SERVICE PLAN COMMENTS

STERLING RANCH EAST			
OVERALL SITE EXHIBIT			
DESIGNED BY	EAS	SCALE	DATE 03/23/2022
DRAWN BY	EAS	(H) 1" = 300'	SHEET 1 OF 1
CHECKED BY	(V) 1" = N/A	JOB NO.	1183.10

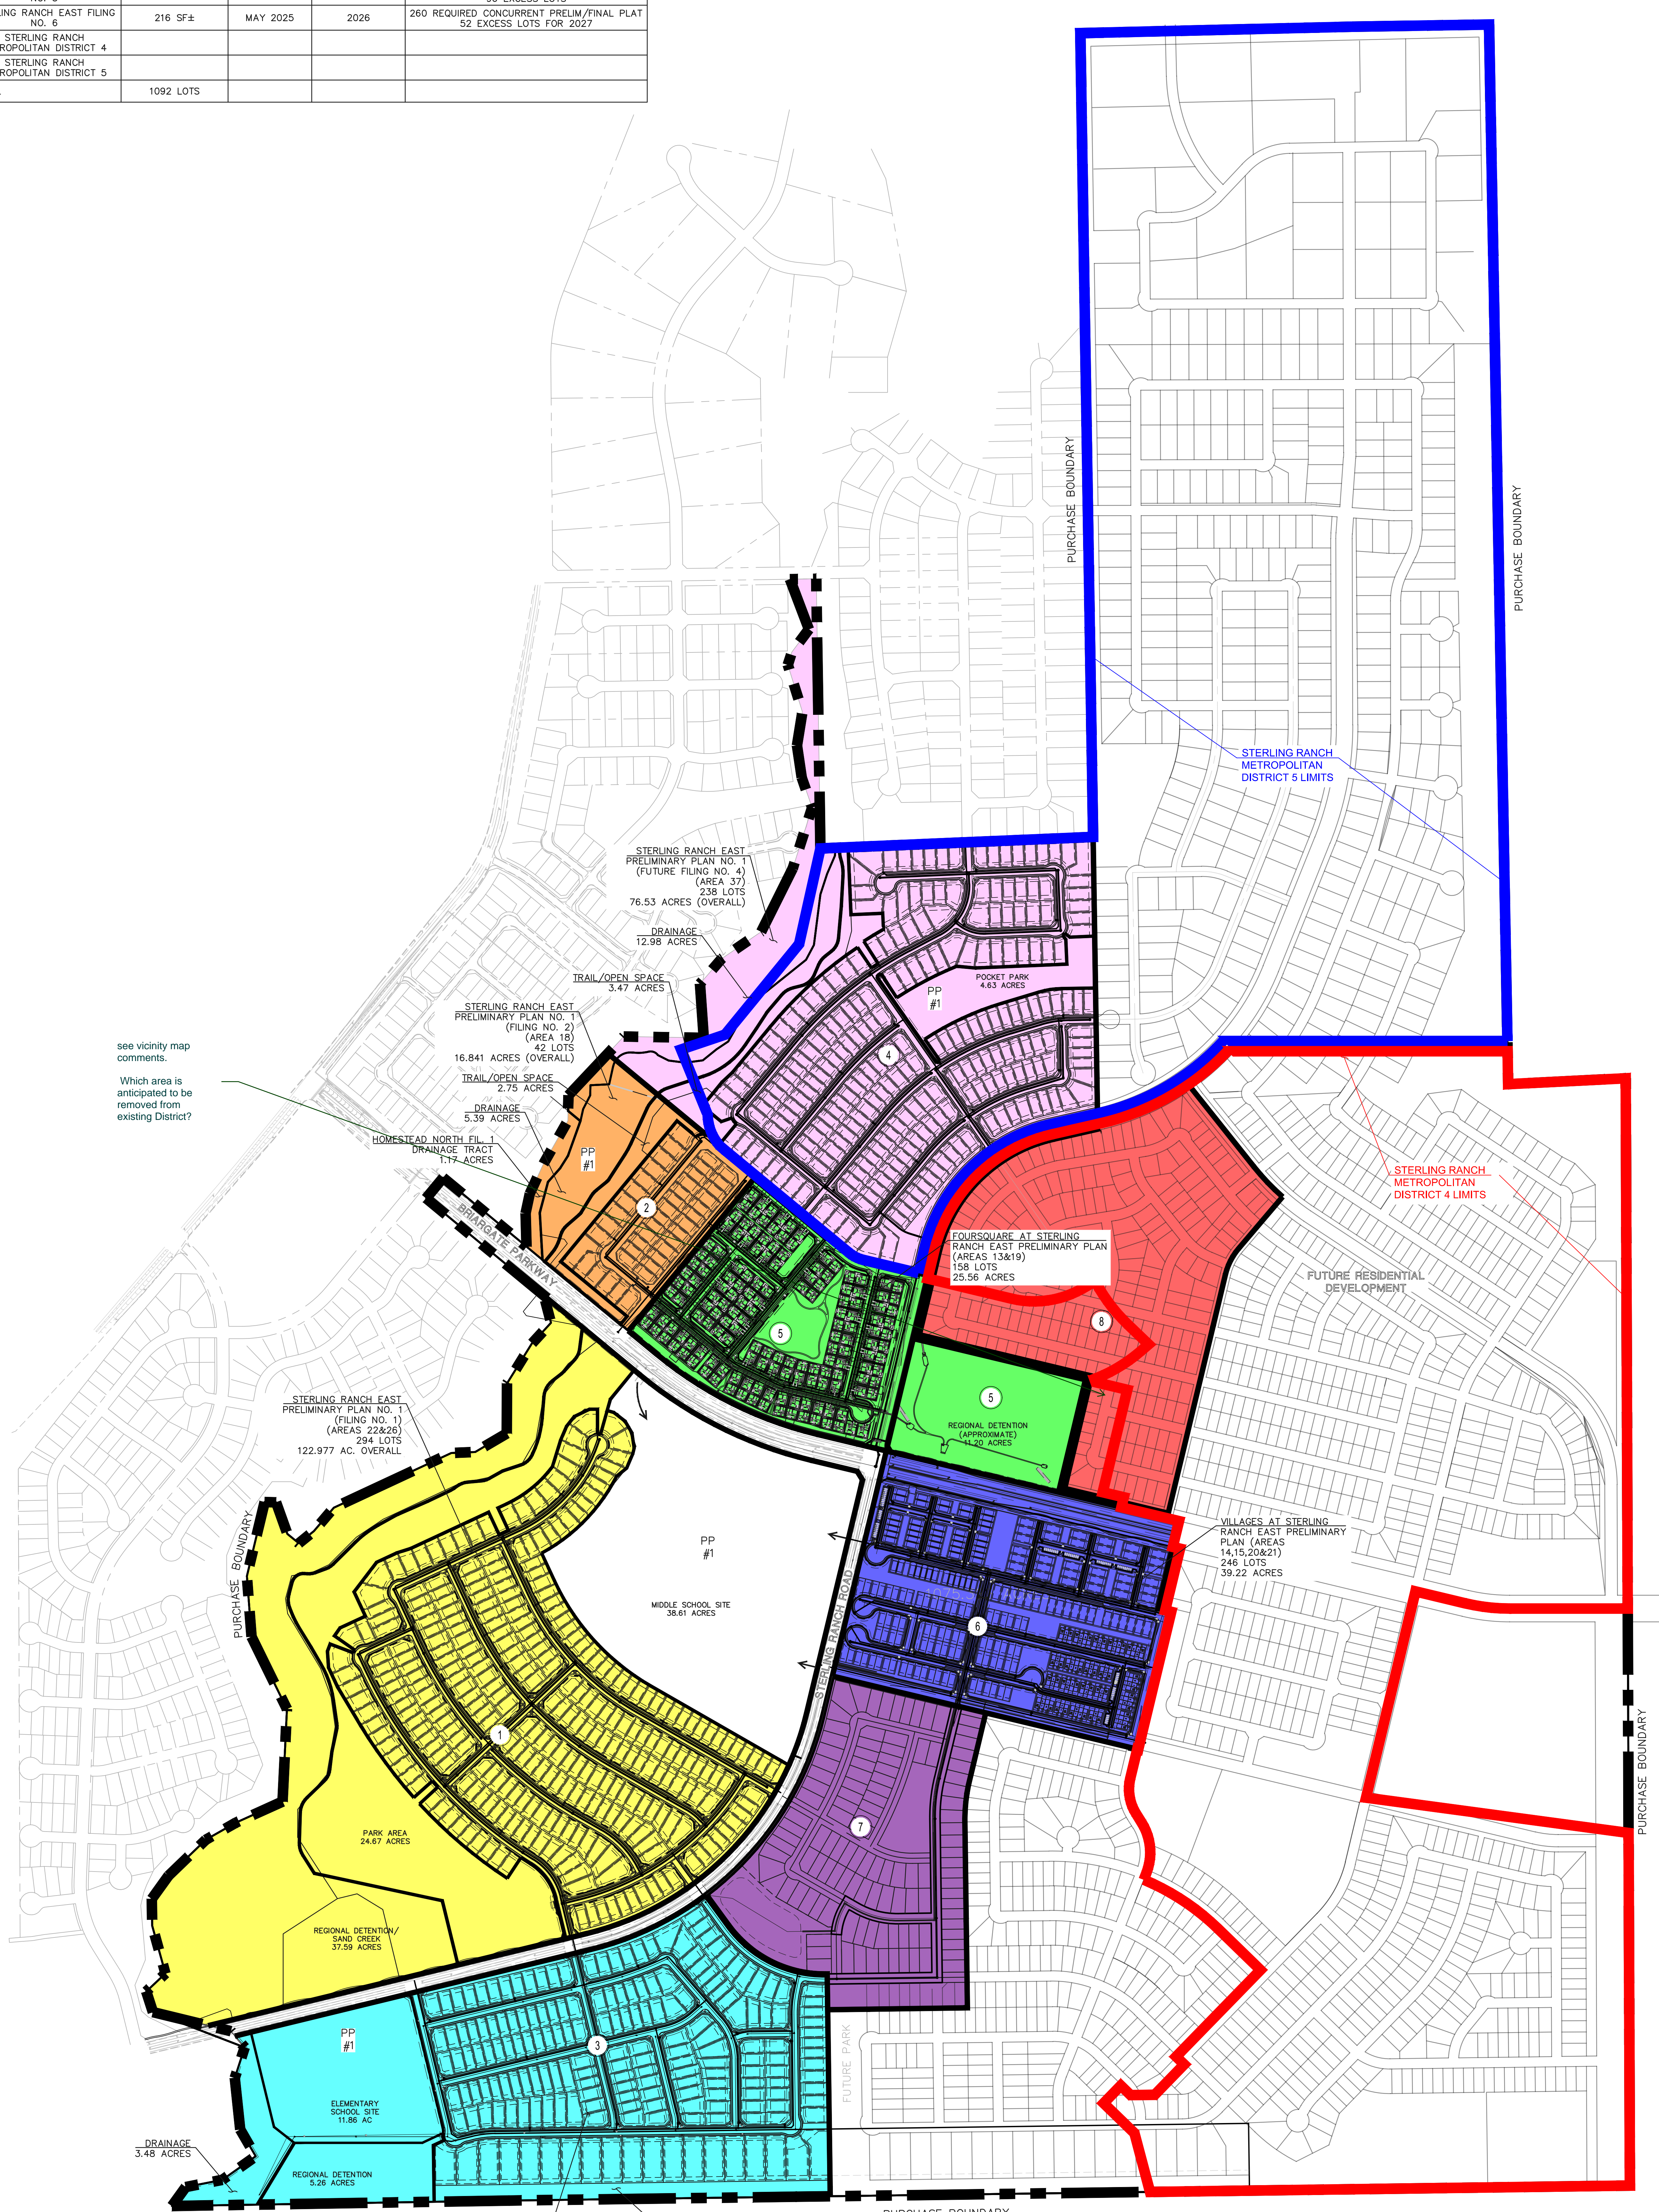
27.	Label exhibits based on Table of Contents	Revised.
28.	Boundary Map – label existing Districts	Included information regarding overlap, see table in upper right corner for information regarding filings.

29.	Boundary Map – explain how overlap is addressed/how exclusion process works	The property will be excluded from Sterling Ranch Metropolitan District No. 2. This is done by a petition from the property owner. Upon the approval of District No. 2, a motion will be filed with the court, requesting an order to exclude the property from District No. 2’s boundaries.

EXHIBIT A-4
ADDITIONAL INCLUDED PROPERTY MAP

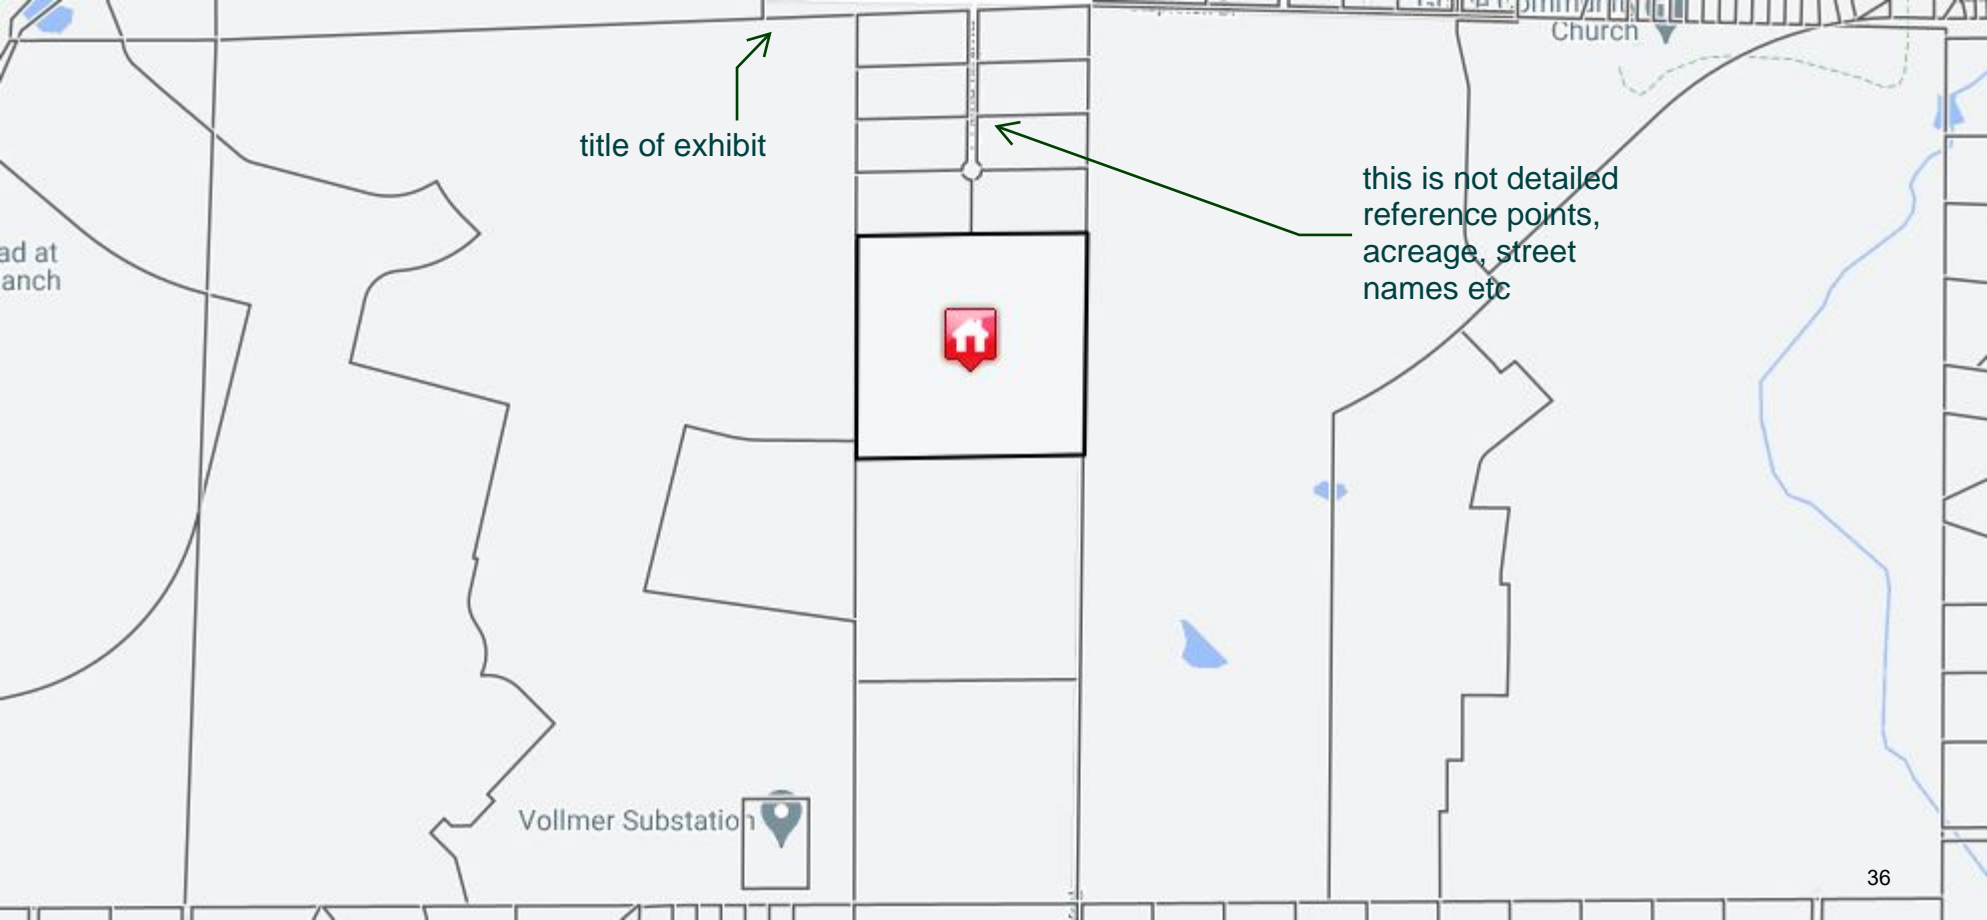
30.	Exhibit A-3 – Provide the basic improvement maps (water, wastewater, streets, utility, open space/trails, stormwater and drainage)	Revised.
31.	Exhibit A-4 – Need a more detailed map of future inclusion area that better depicts surrounding area	Revised.
